WALBERTON PARISH COUNCIL INCLUDING FONTWELL AND BINSTED

Ref: Planning application WA/2/22/OUT - Land West of Yapton Lane

Walberton Parish Council **objects** to this planning application. The grounds for this are detailed below:

AGRICULTURAL LAND CLASSIFICATION

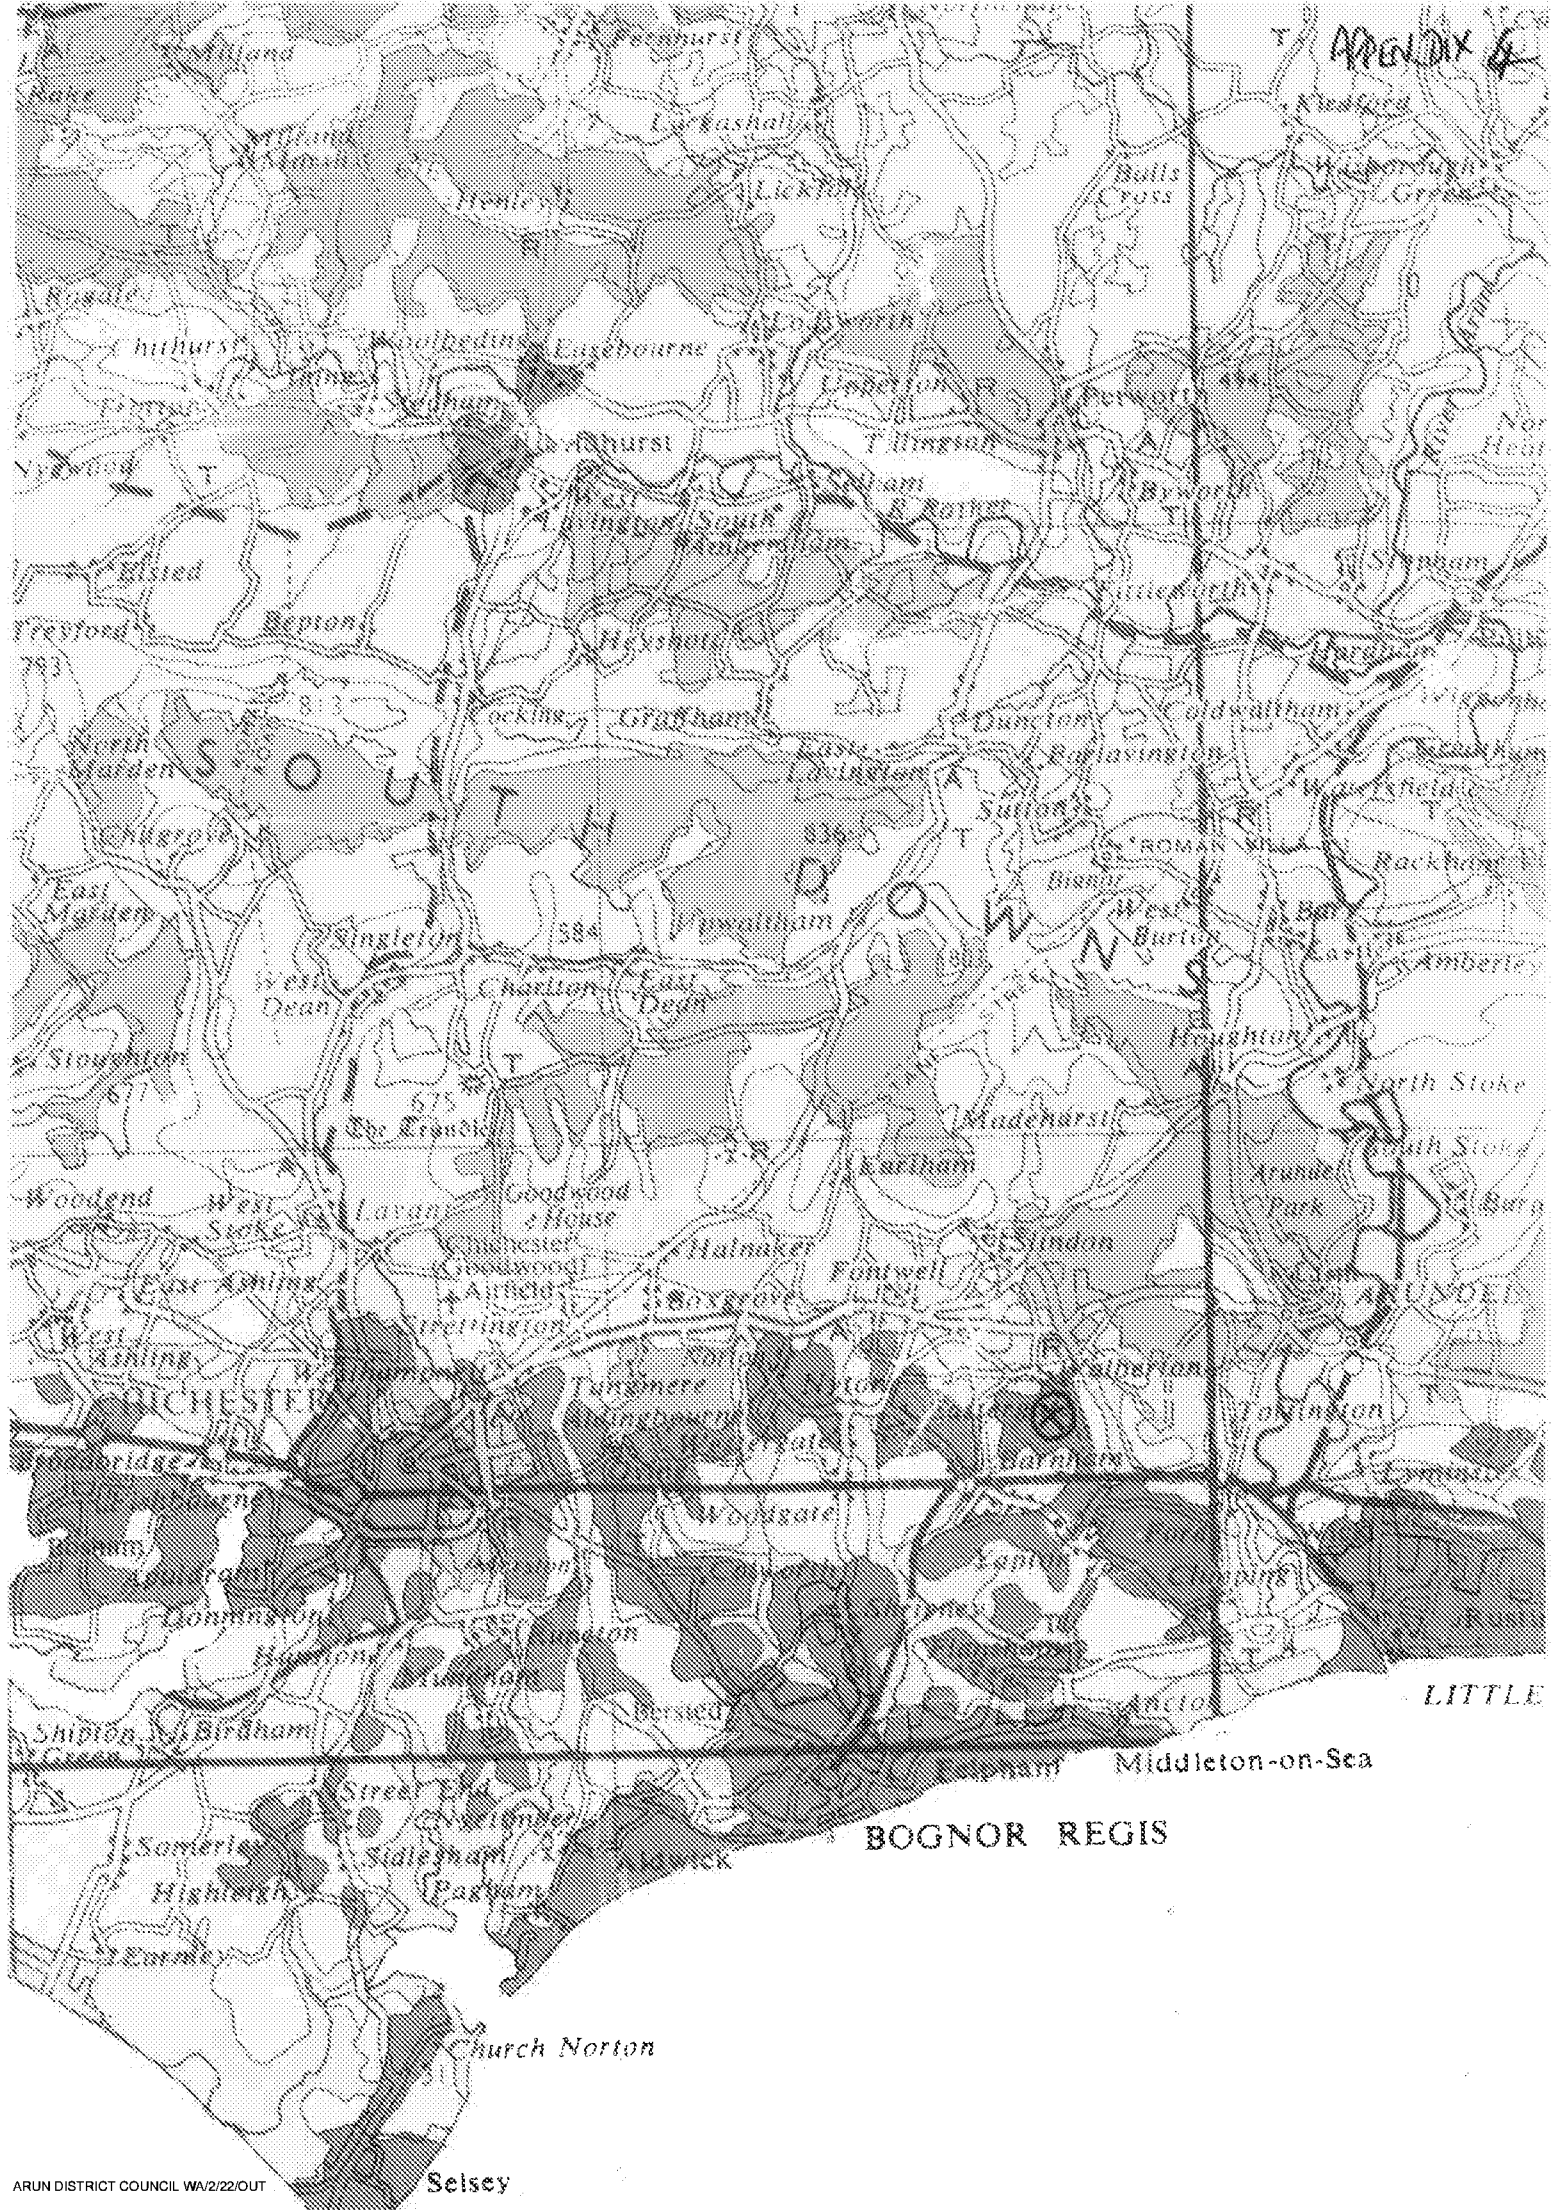
- The site is grade 1 agricultural land. Use for development as required by ALP Policy SO DM1 has not been demonstrated. For example, no consideration to DEFRA's Soil Strategy for England is referenced.

Figure 3: Public Rights of Way

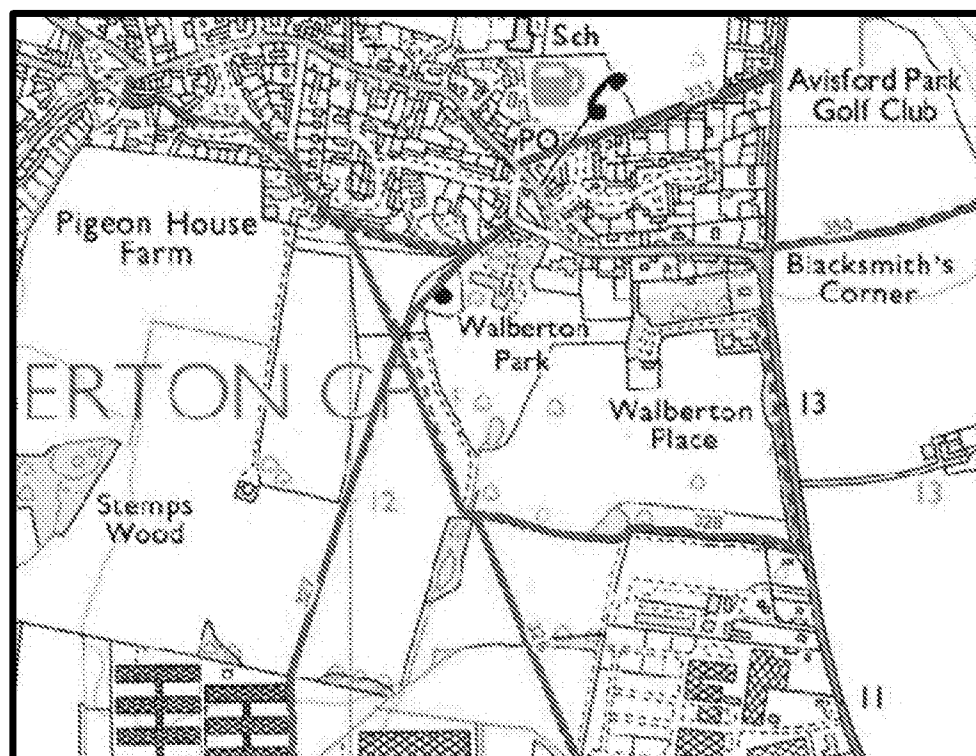
- Pedestrian access to the development is unclear. There are no pavements along Yapton Lane and the 'permissive path' in its current form is not practical for general use.

Figure 4: Summary of Personal Injury Accident Data

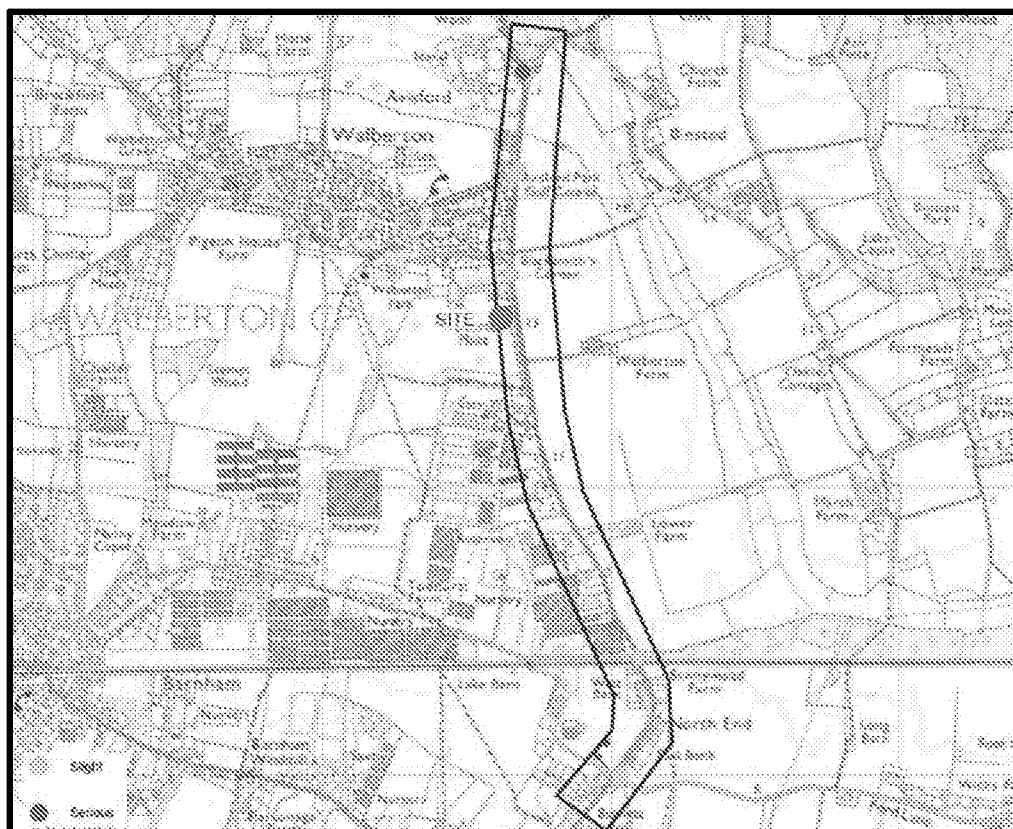
- We dispute that the local highway network is completely safe for cyclists to use – the accident data provided by the applicant includes collisions with both a bicycle and a pedestrian.
